## WEST SUSSEX COUNTY COUNCIL CONSULTATION

<b>TO:</b>	Arun District Council FAO: Hannah Kersley
<b>FROM:</b>	WSCC – Highway Authority
<b>DATE:</b>	28 January 2026
<b>LOCATION:</b>	Local Centre and Phase 6b Hampton Park Littlehampton
<b>SUBJECT:</b>	LU/250/25/RES Approval of reserved matters following the grant of LU/47/11/ (amended by LU/182/15/PL) for 111 No dwellings, 1472sqm of retail floor space, 418sqm of community centre floor space, a civic public open space (0.35ha), a community car park and a super LEAP (incorporating fitness equipment / trail) comprising 0.62ha.
<b>DATE OF SITE VISIT:</b>	n/a (desktop study undertaken – site visited previously)
<b>RECOMMENDATION:</b>	More Information Required

Status:	PLANNING	Rev. -
Scale. 1-500 @ A1	Project No. 011042	Dwg No. PL - 100
Date: 28.11.2025	Drawn By. ST	Chk. AS

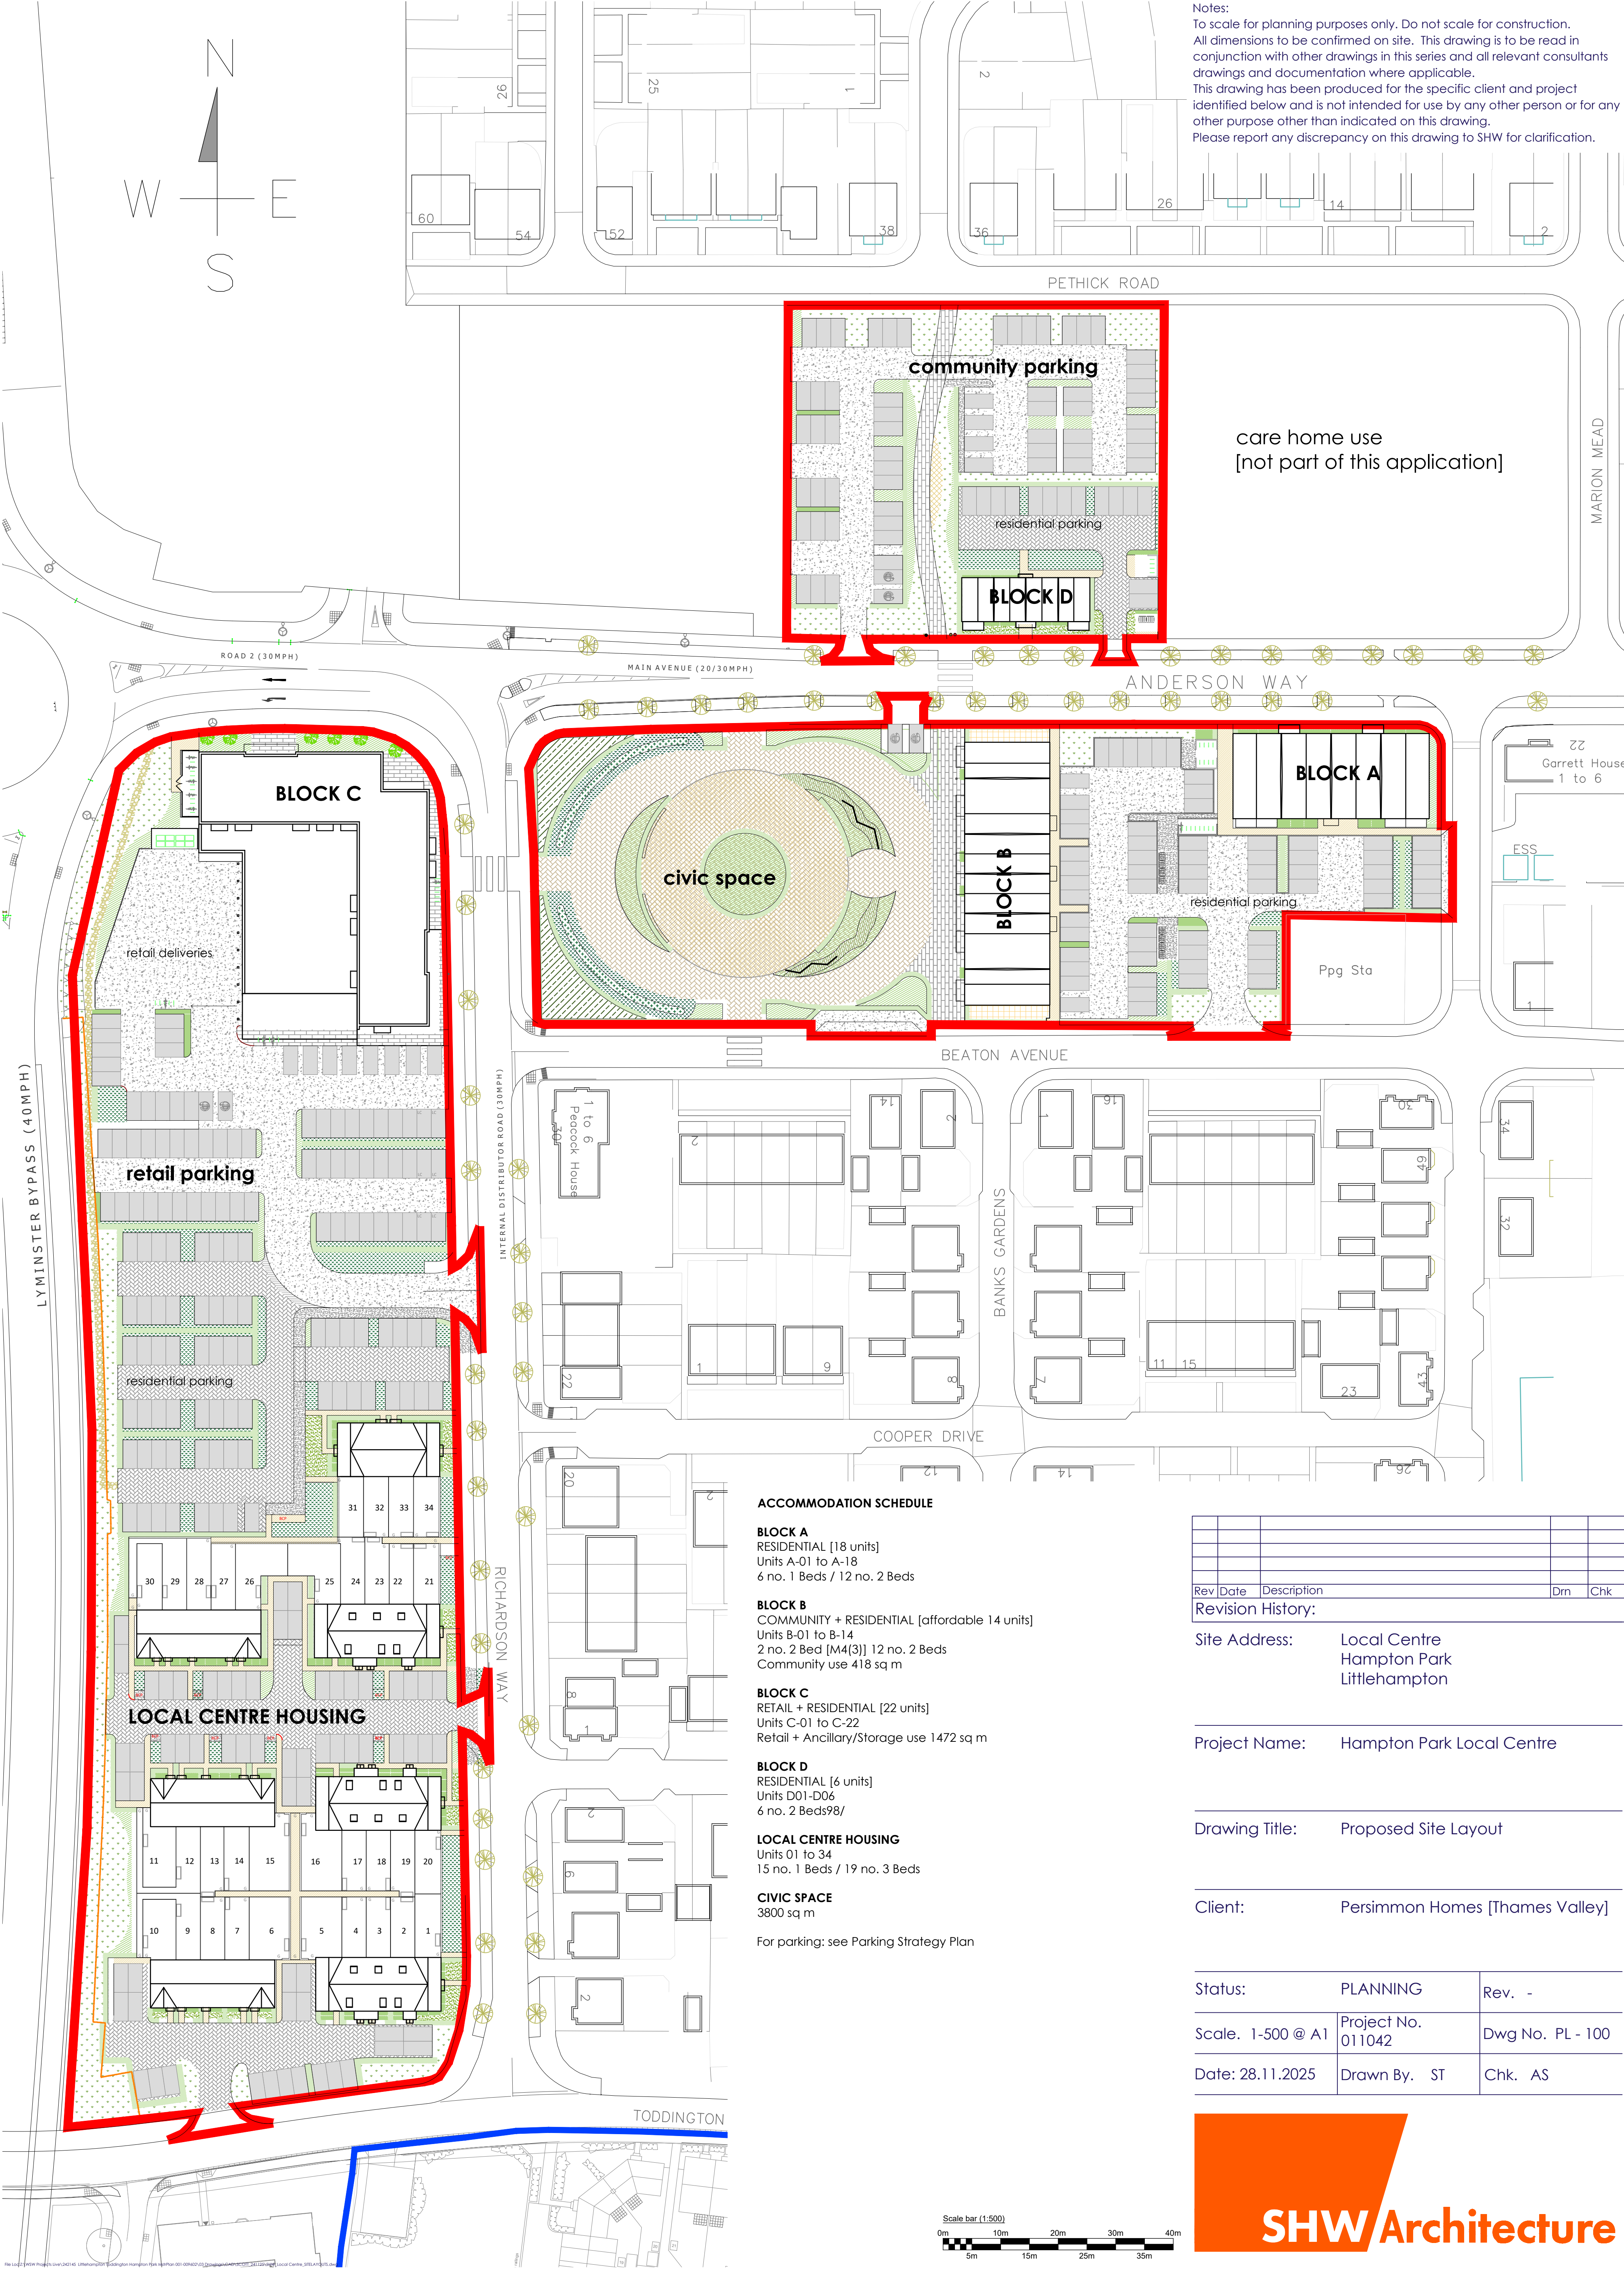
- Zebra-style crossing points are shown at three locations (Richardson Way, Anderson Way and Beaton Avenue). While the plans might show architect's interpretations of zebra-style crossings, if they are to be provided, they will need to be designed in accordance with relevant design guidance/standards and shown as such on amended drawings. They will also need to be Safety Audited. A DRAFT Decision Log in tabular form should accompany the Audit. Also, TROs might also be required for them. Applicant to clarify what they are and whether they intend to provide them.

- Please explain what 'community parking' area is for.
- Access to Toddington Lane for southern part of the development would be a new access point. As such, visibility splays, appropriate to the posted speed limit on Toddington Lane and taken from a 2.4m 'x' distance, need to be shown on an amended drawing. It is also recommended that separate pedestrian access be shown from Toddington Lane to that part of the development.

- Visibility splays to be shown on an amended plan for ALL access points.
- Applicant should explain why two EV parking spaces are shown accessing onto Anderson Way and shown close to the possible zebra-style crossing. Given that they would require reversing across the adjacent shared foot and cycle path, it is recommended that they be removed and moved to one of the adjacent car parks instead.

- With regard to the commercial Block B, the applicant should consider the provision of waiting restrictions on Richardson Way and Main Avenue/Anderson Way to prevent indiscriminate on-street parking that might obstruct access points and/or the carriageway. Some on-street parking is already observed close to the access off Richardson Way. The cost of a TRO must be borne by the applicant, including provision of any associated infrastructure that may be required to implement it (e.g. signage and lining etc). Additionally, informal consultation about this with the Local County Council Member and other interested parties will be required to be undertaken by the applicant and the response made available to the author following this. Full details can be found on the WSCC website.
